Planning reference LU/13/15/PL

Proposed Residential Development,
The Old Dairy, Church Street, Littlehampton.

SOUTH ELEVATION PLOTS 1 TO 5 PROPOSED

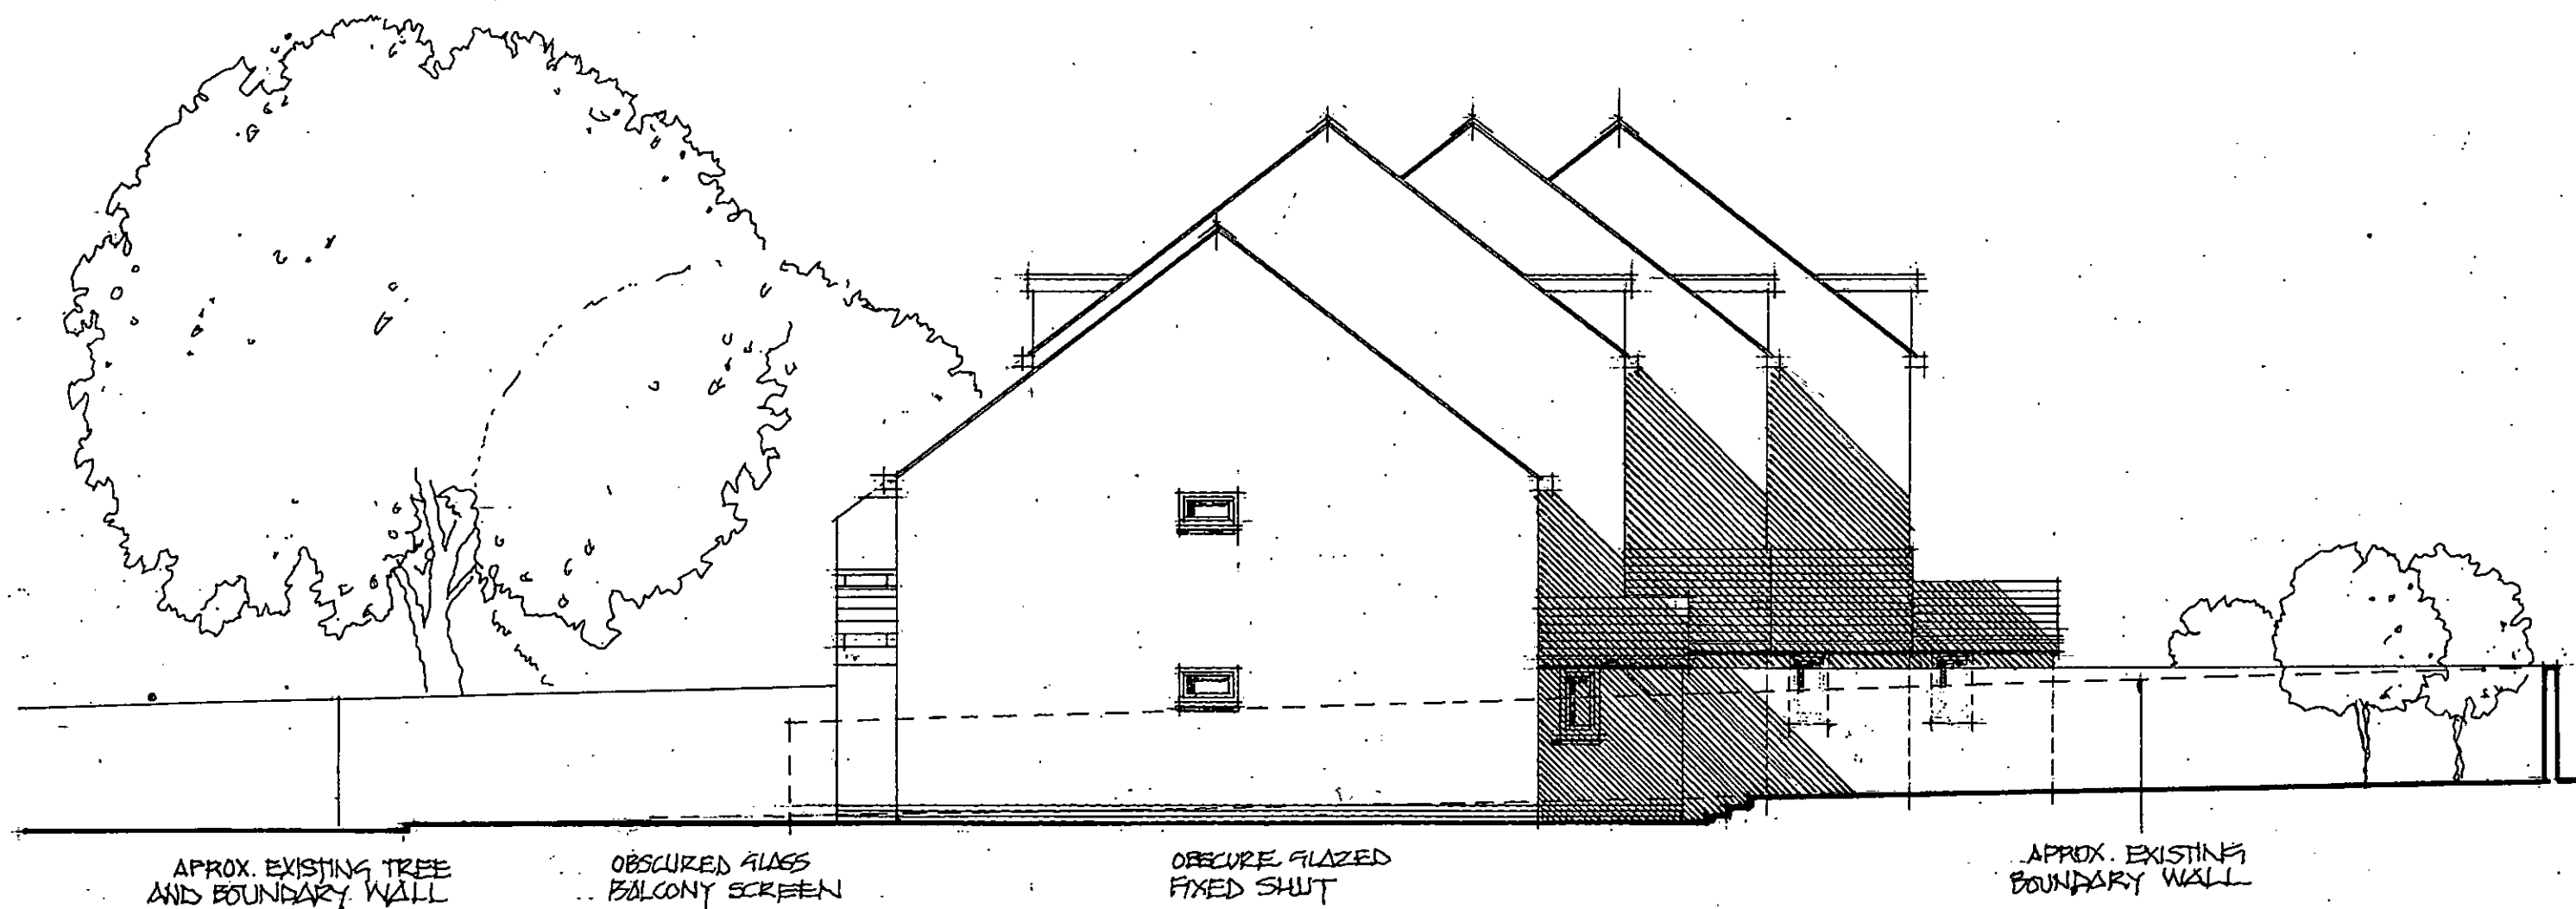
I refer to the above application and wish to raise an objection in respect of the height of the three-2½ storey houses to be built at the above development at the rear of my property, No. 19, Goda Road, which would be intrusive by overlooking and overshadowing my garden, particularly by the windows in the roof by the extra ½ storey. Surely normal 2 storey houses here and at the rear of Nos. 11 and 13, Goda Road, as in the case of Plots 1 and 2 shown on the site plan, would be less of an overdevelopment and more in keeping with the locality.
